Our reference: P -1169563-P7F1
Contact: Sandra Fagan
Telephone: (02) 4732 7992

3 June 2026

**Council Advice on Modification Report – SSD-23480429-Mod-2 –
Westgate Kemps Creek Warehouse 1 at 253-267 Aldington Road Kemps
Creek**

Warehouse 1B to 1D Floor Plan

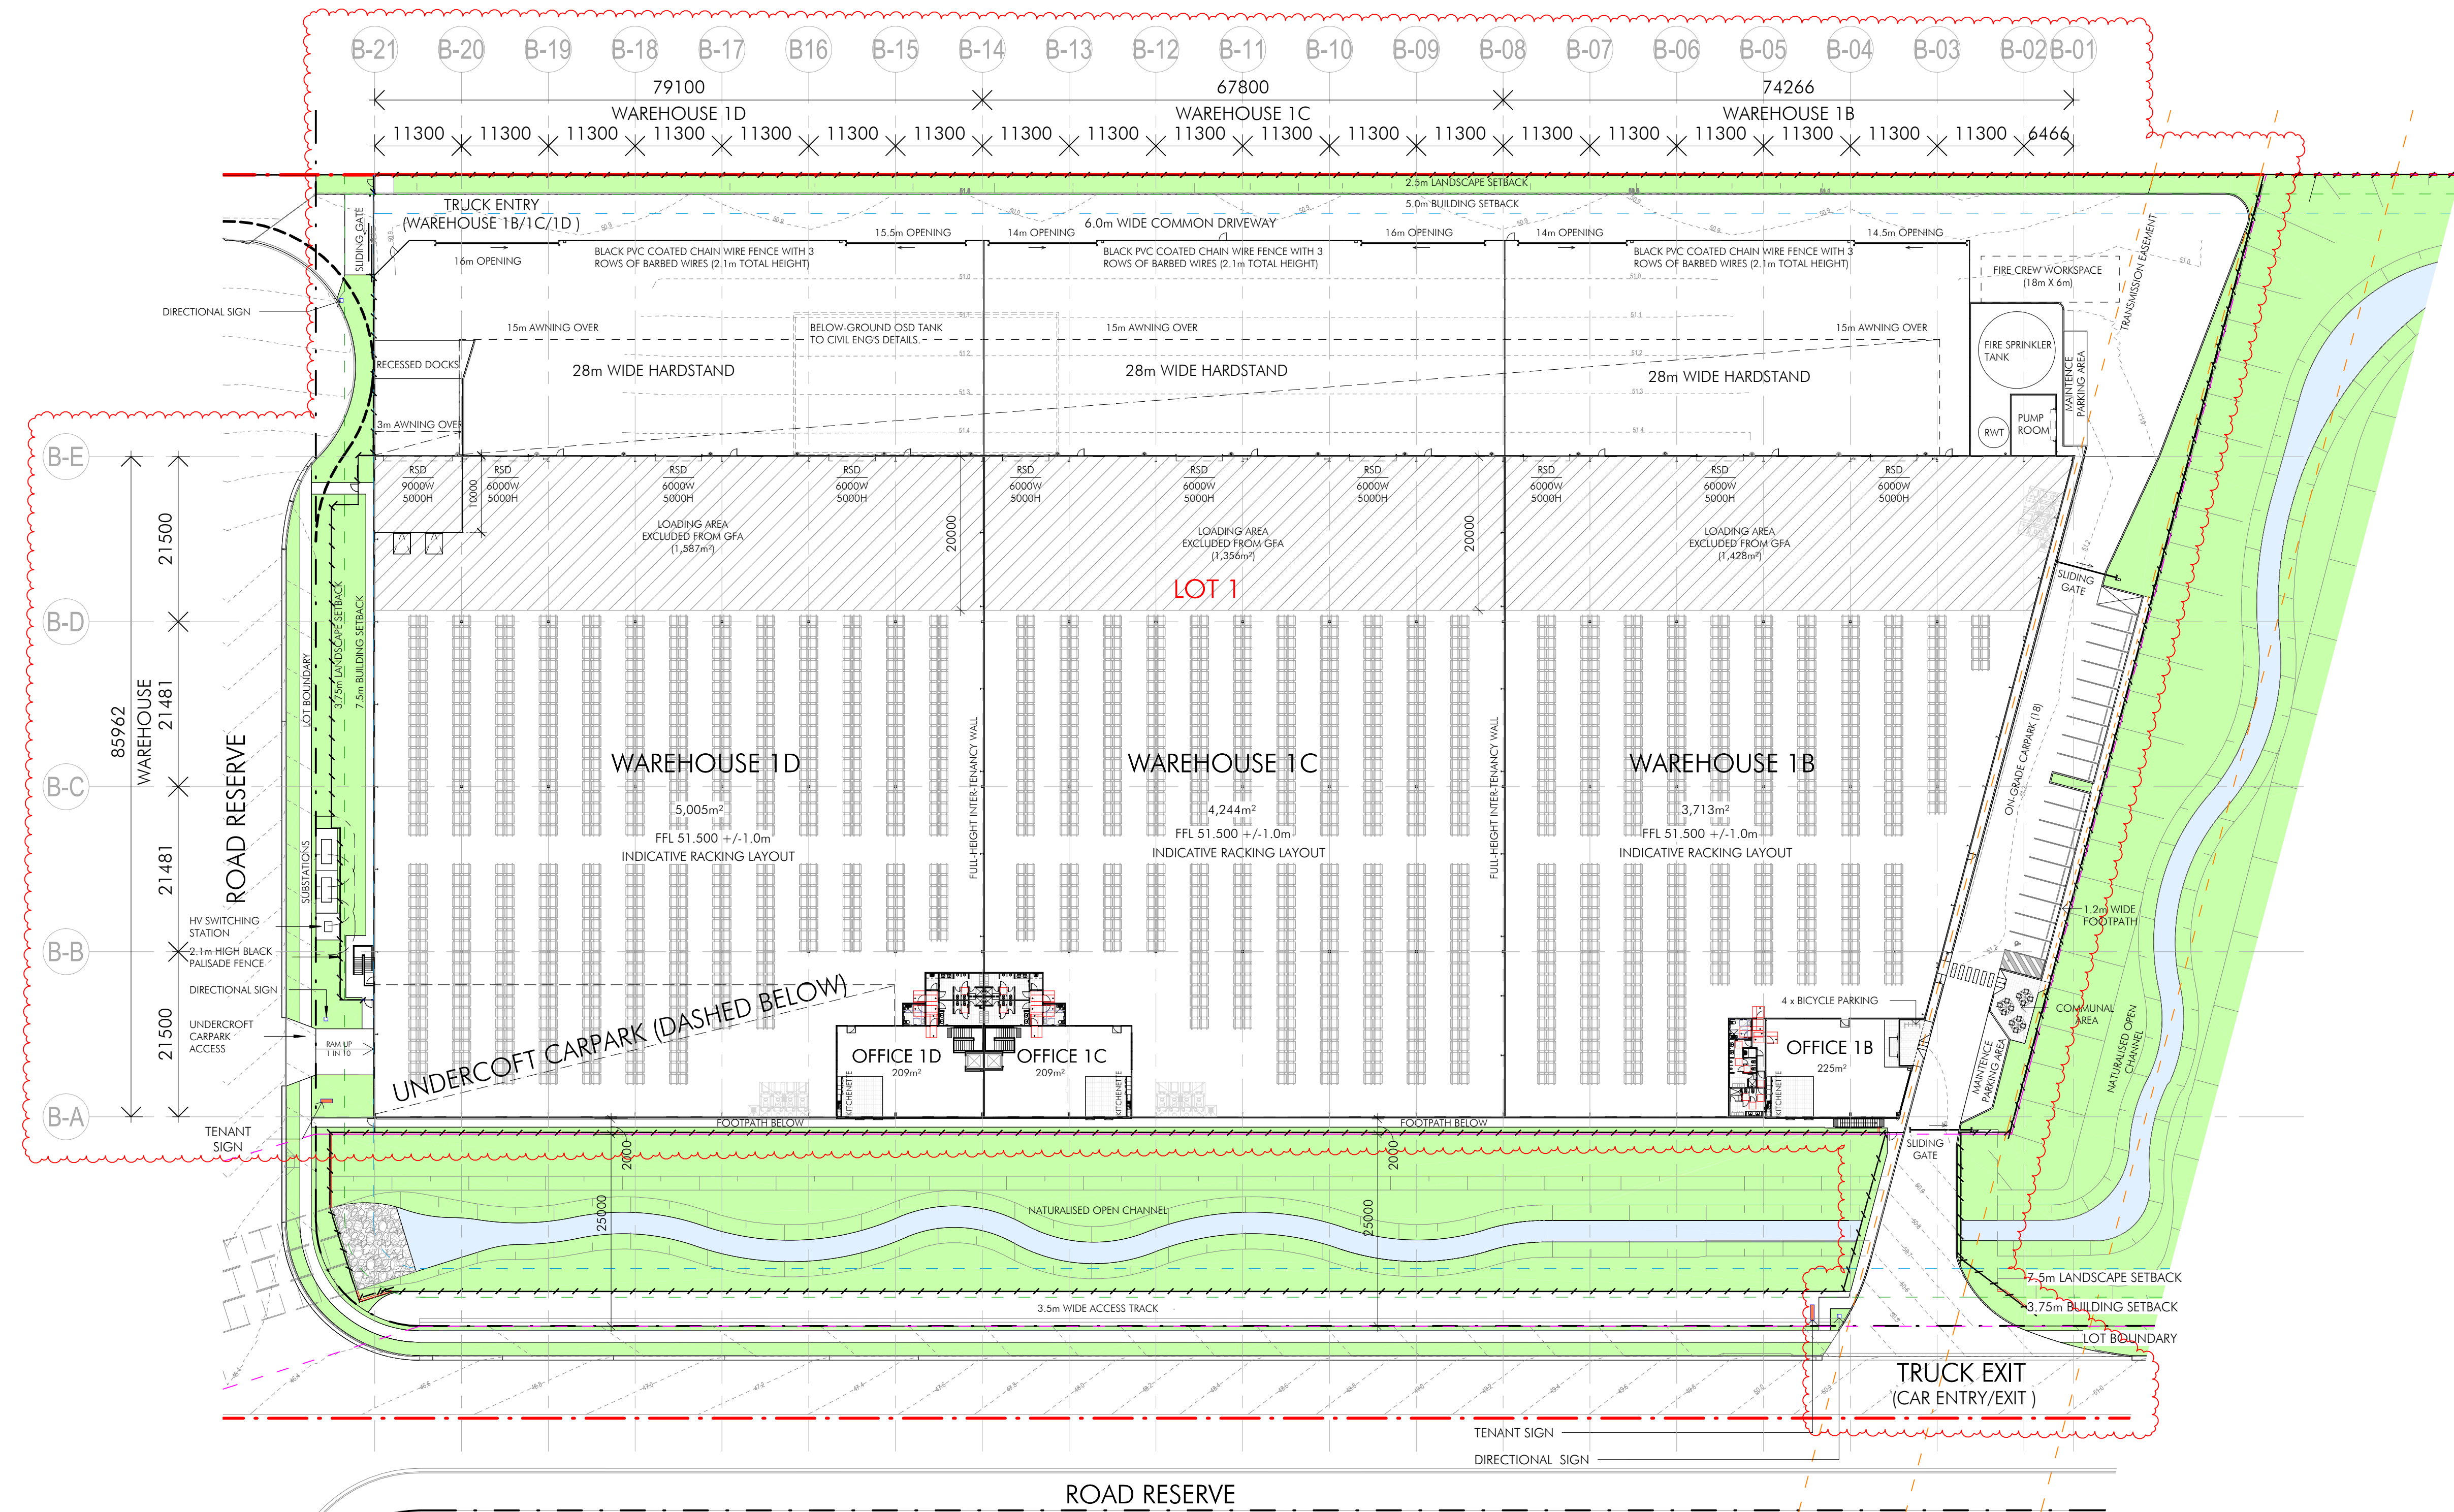
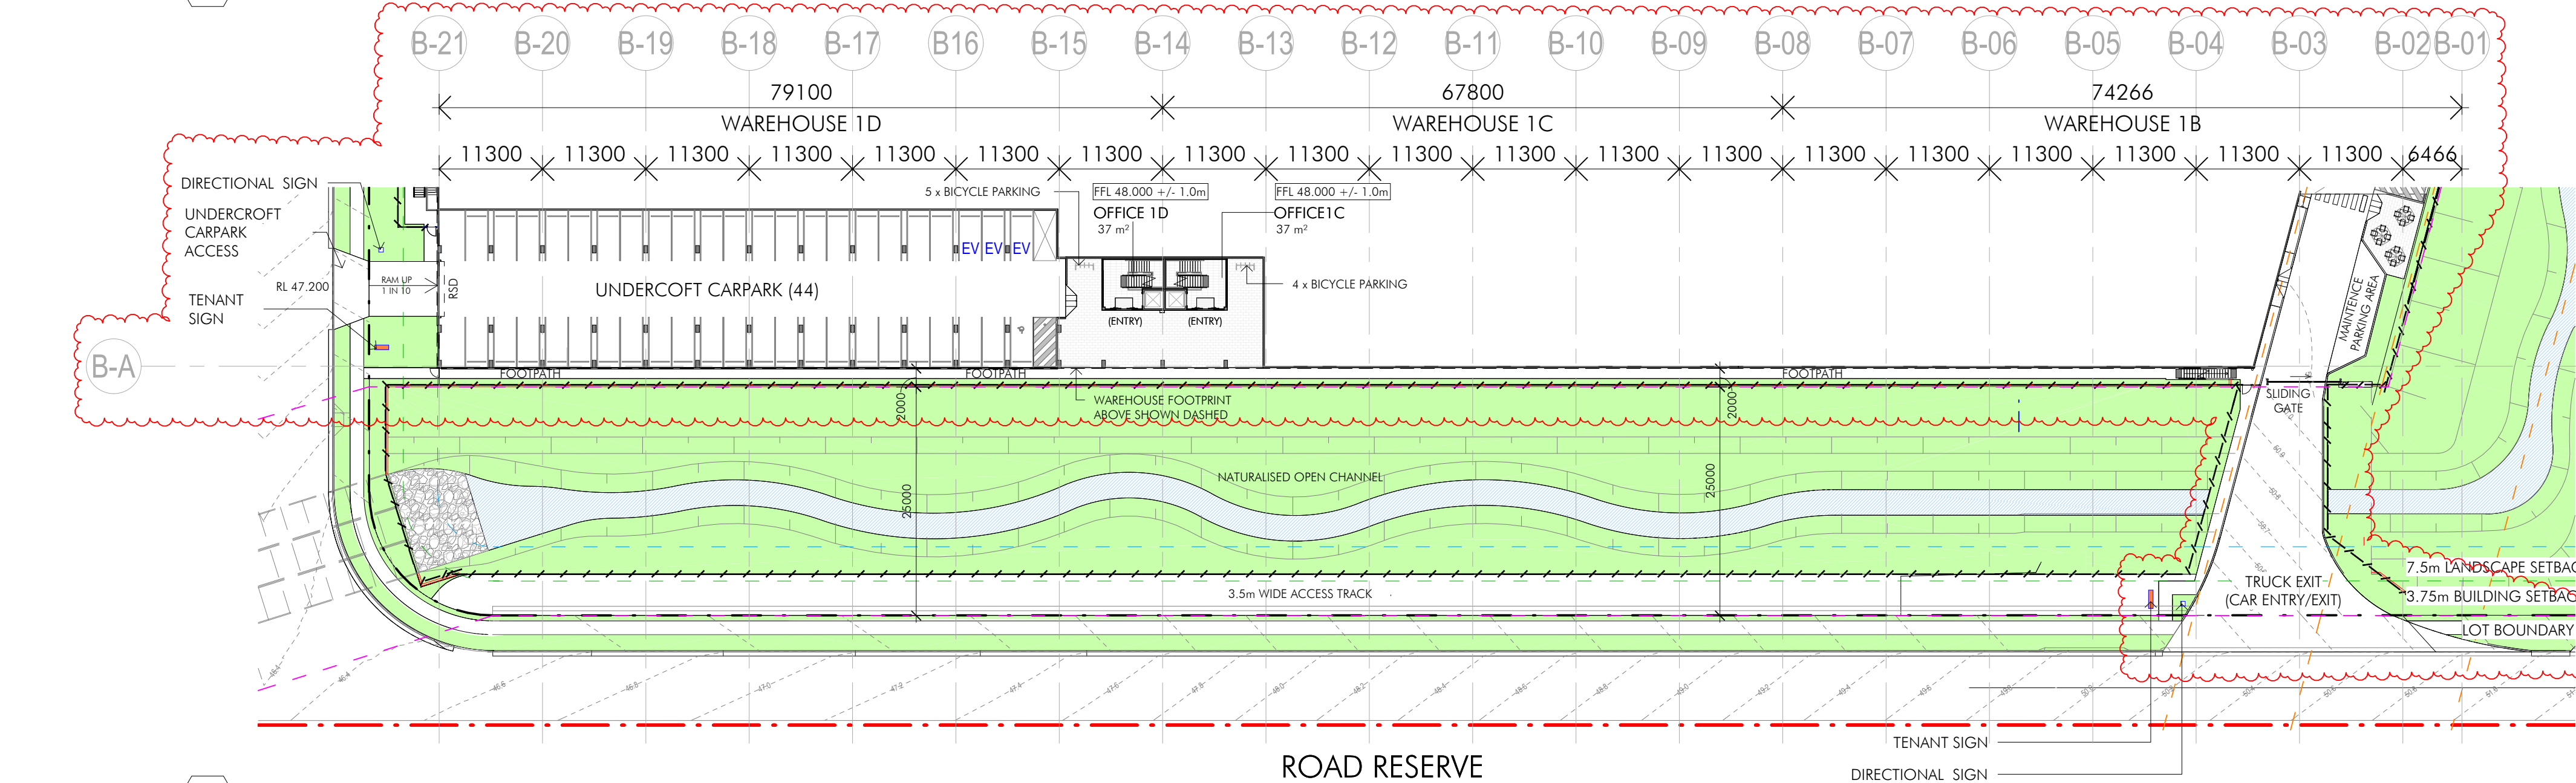
- c) The proposal includes an additional at-grade car parking area intended to be utilised by Warehouse 1B, thus allowing Warehouses 1C and 1D to use the approved (modified) under-croft parking area. Access to the new at-grade car parking area, for cars both entering and exiting, is proposed to be from the approved truck exit driveway. The proposed at-grade car parking area is located off the approved truck manoeuvring path and will require cars to use the same swept path as trucks (26 metre B-doubles) travelling in a southerly direction seeking to exit the site.

- d) It is noted that the existing SSD Approval provides for a combined under-croft car parking area that Warehouses 1B and 1C were able to share, and which was accessed from a separate driveway dedicated to light vehicles. The current approved design therefore avoids conflicts between cars and trucks, both in relation to access driveways and manoeuvres on lot.

- e) There is no objection to the repositioning of the under-croft car parking area which will be shared by Warehouses 1C and 1D. However, the proposed at-grade car parking area for Warehouse 1B will result in a poorer outcome than the current SSD Approval in relation to safety and amenity for staff / visitors.

- f) The resulting shared access for heavy and light vehicles, as well as bicycles to Warehouse 1B, and the shared manoeuvring arrangement for part of the travel route, does not satisfactorily avoid conflict between heavy vehicles and staff, customer and visitor vehicular and bicycle movements.

- i) In addition, it appears that the proposed at-grade car parking area is positioned within approved deep soil on-lot landscaped area, resulting in further loss of overall landscaped deep soil areas and reduction in site perviousness.

- j) A more appropriate outcome, if an additional tenancy is sought, is to extend the existing approved under-croft parking area, and/or have a combination of both the approved and proposed under-croft parking areas within the warehouse footprint. This will maintain separate access and manoeuvring for cars, cyclists, and pedestrians from truck access and manoeuvring areas. While it is acknowledged that this will result in a loss of warehouse GFA, it would be a better outcome for future staff/visitors than the current proposed modification.

- k) The proposed modifications also result in the office entry for Warehouse 1B being positioned off the truck driveway. The proposed bicycle parking is located at the office entry, meaning that cyclists will access the parking spaces by using the same driveway as the exiting trucks, and using a portion of the same truck manoeuvring path. The position of the car parking area relative the proposed office will also require staff and visitors to traverse the truck route. The proposal shows a pedestrian crossing across the truck manoeuvring route, which is a safety concern.

- l) The proposed communal area with seating is positioned adjacent to the car parking area for Warehouse 1B and the truck manoeuvring area. This also results in a poor amenity and safety outcome. The SSD Approval had balconies designed into the office spaces which is a better solution to provide amenity for staff.
- m) The Proponent should clarify whether any changes to the interim stormwater management solution is proposed as part of this modification. It is understood that there are no changes proposed, however, one of the drawings in the Modification Report (at paragraph 3.4.2) shows a plan titled Figure 3: Interim Water Management Plan, which shows a change to the interim evaporation pond on Lot 2. The accompanying civil drawings also include this plan (21-860-C250 Issue 1). This should be clarified with DPHI and Sydney Water.

- a) The modification proposes design changes to the approved Warehouse 1B and 1C on Lot 1 including a modified tenancy split to allow an additional tenancy, a modified parking provision of 62 spaces and relocation of the driveway location to the undercroft car park to the west end of the lot.
- b) The proposed car parking spaces on Warehouse 1D will be used by staff from Warehouse 1D and Warehouse 1C as separate car parking spaces have been provided for Warehouse 1B.
- c) The proposed car parking provision meets the minimum parking requirements of the MRP DCP.
- d) Traffic generated by the proposed development can be accommodated within the road network without any adverse impact.
- e) It is noted that the proposed access driveway for Warehouse 1B has been designed to accommodate shared access between light and

heavy vehicles, which includes heavy vehicle exit movement and light vehicle entry and exit movements. To ensure safety of the drivers, the Department should consider if this is acceptable as the MRP DCP refers to separate driveways to be provided for heavy vehicles and light vehicles.
